From: Daun Johnson <Daun.Johnson@arun.gov.uk>
Sent: 19 December 2019 08:59
To: Planning.Responses <Planning.Responses@arun.gov.uk>
Subject: FW: AW/198/18/PL 10 Wychwood Close, Craigweil. Reduction in parking space.

From: Bob Lock [REDACTED]
Sent: 18 December 2019 16:30
To: Planning <Planning@arun.gov.uk>
Subject: AW/198/18/PL 10 Wychwood Close, Craigweil. Reduction in parking space.

Site Plan

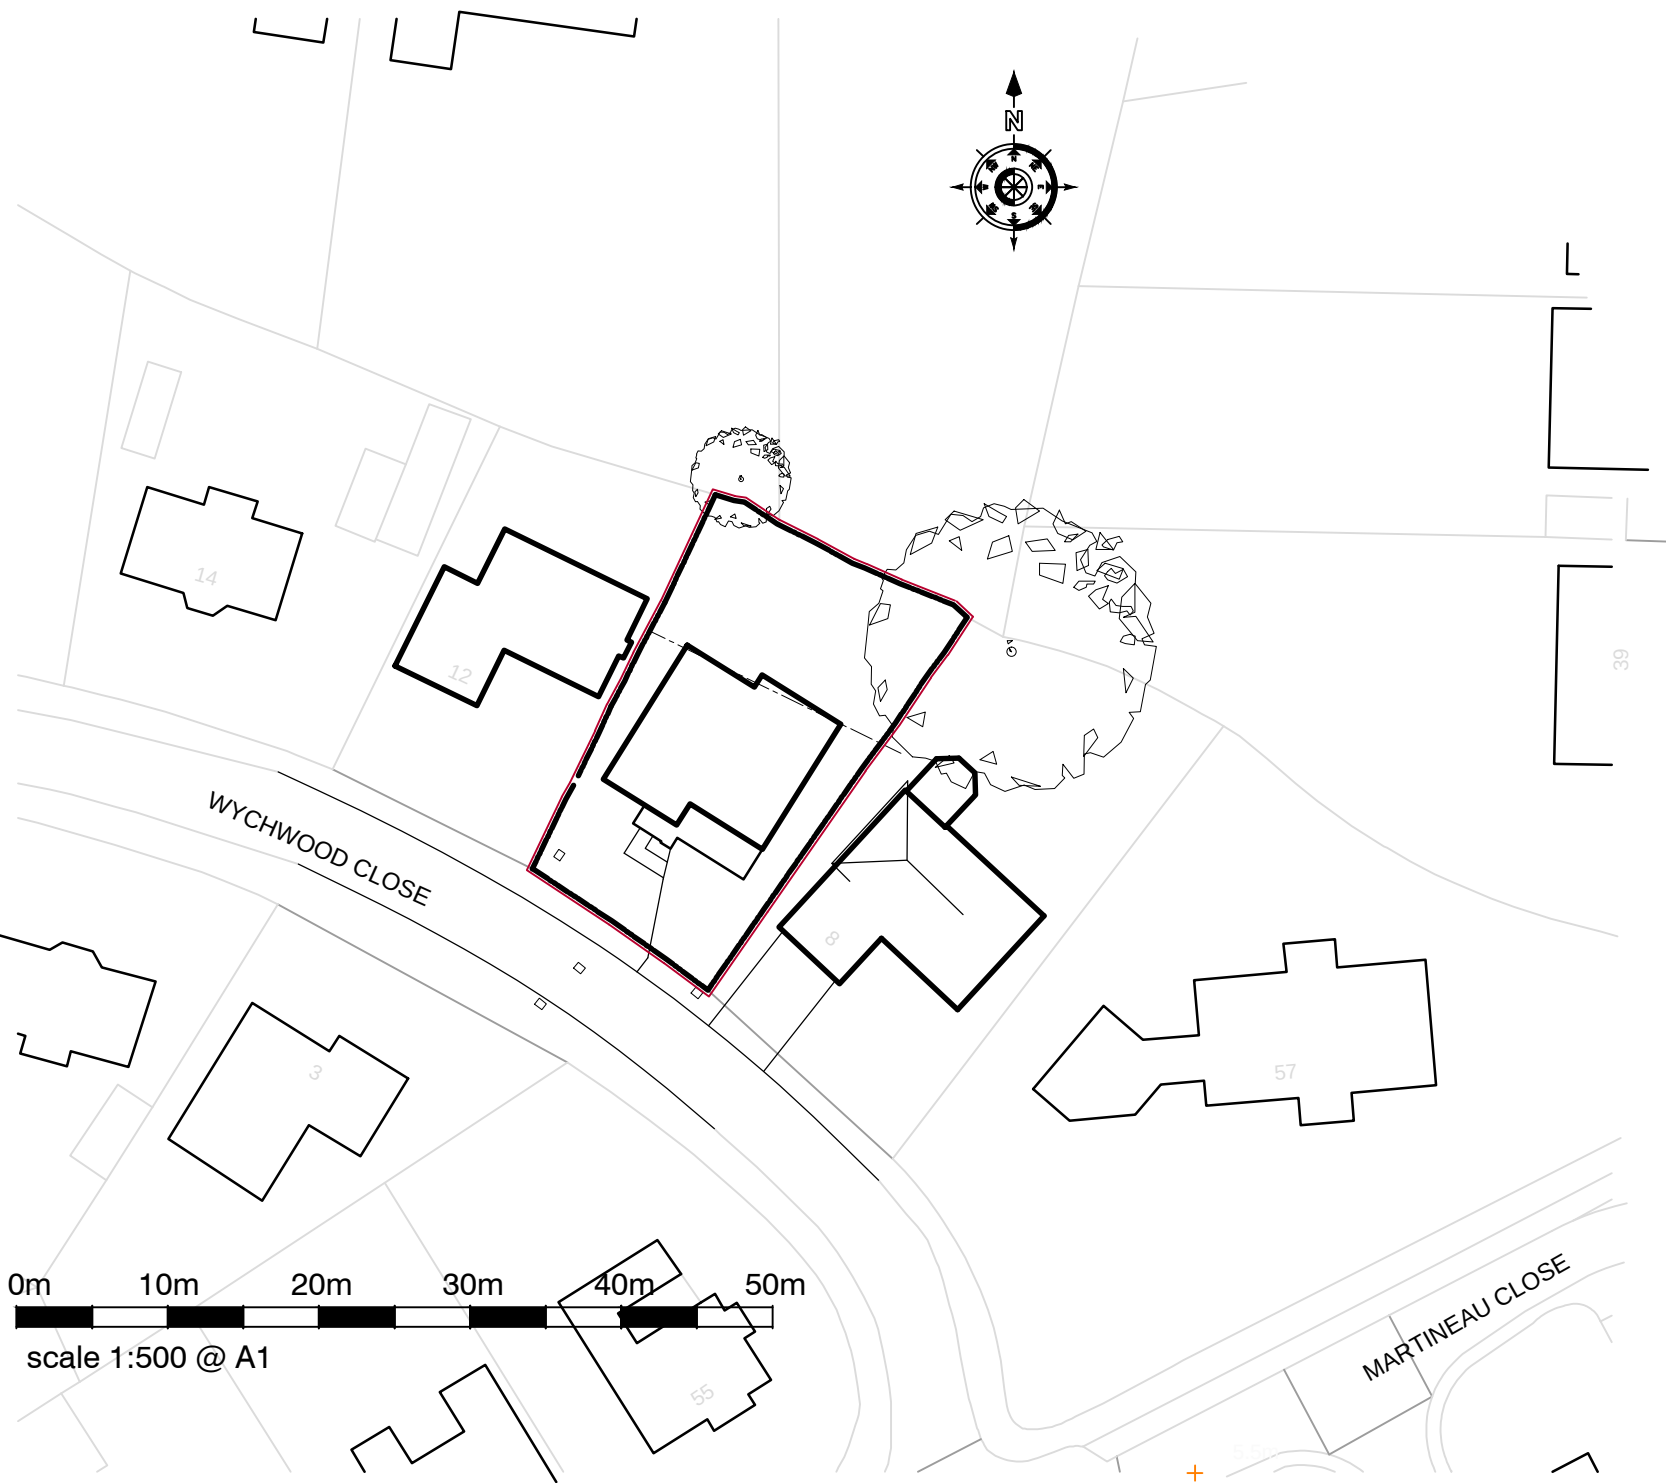
There is concern that the garage now contains an extra construction that would prevent the use of the garage for parking a vehicle. The planning consent shows parking for three cars, there being two cars on the drive, and a third inside the garage. Although this appears to be a double garage, part of the interior is taken up with a utility room.

CPEL would ask that the parking provision for three vehicles on the property as specified in the planning consent, is not eroded.

Ground Floor

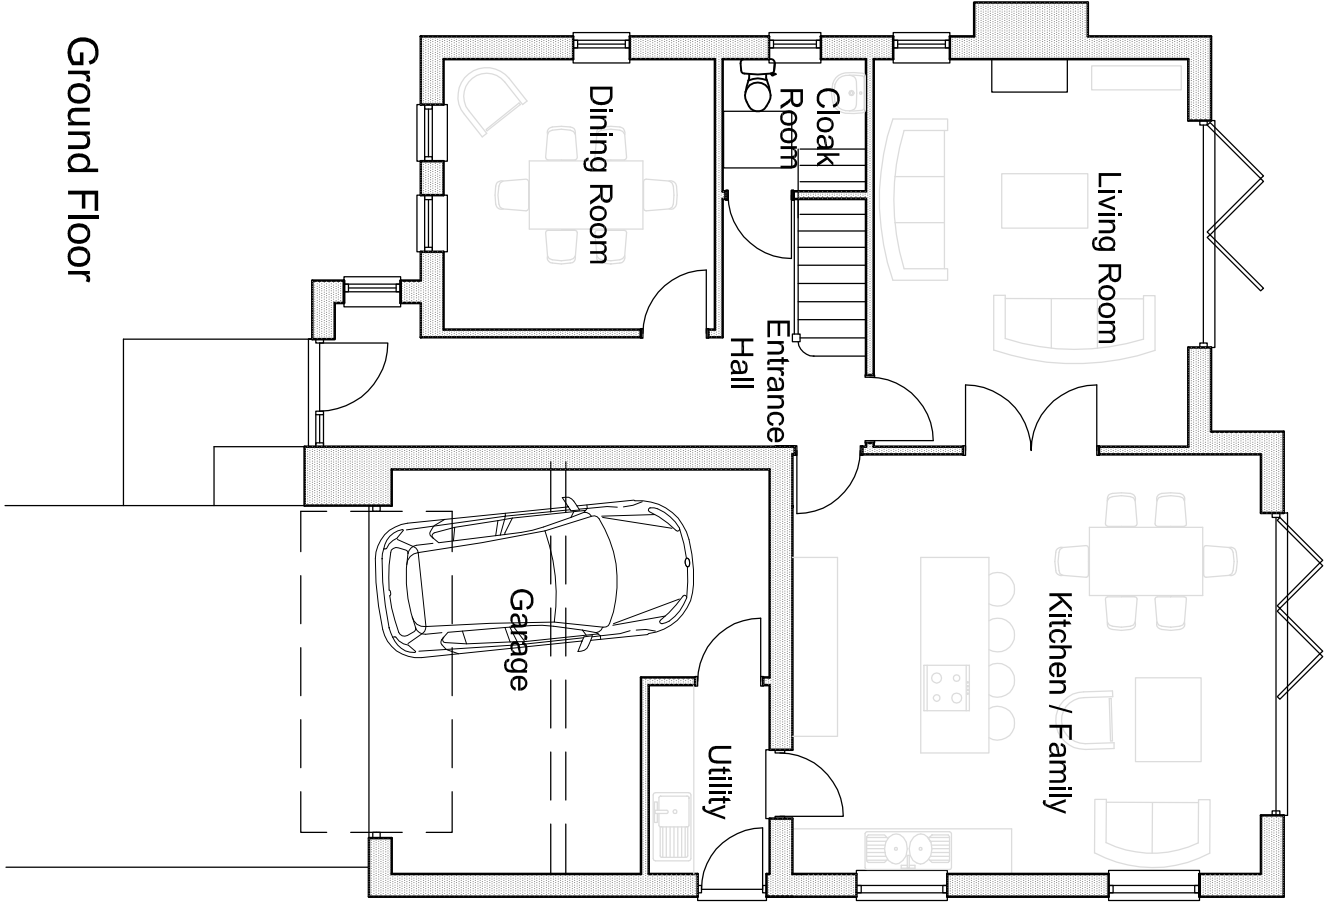
On Tuesday the 17th December I visited the site and spoke with Mr Gary Cotton, contracts manager for the developer. The area of the garage shown as a parking space now has a small plant-room installed against the back left corner. This would appear to prevent all but the smallest sized car from parking within the garage. We measured the length of parking space now available and found it to be 4mtrs. Mr Cotton mentioned that it would be possible to provide parking for three vehicles on the drive by making minor adjustments.
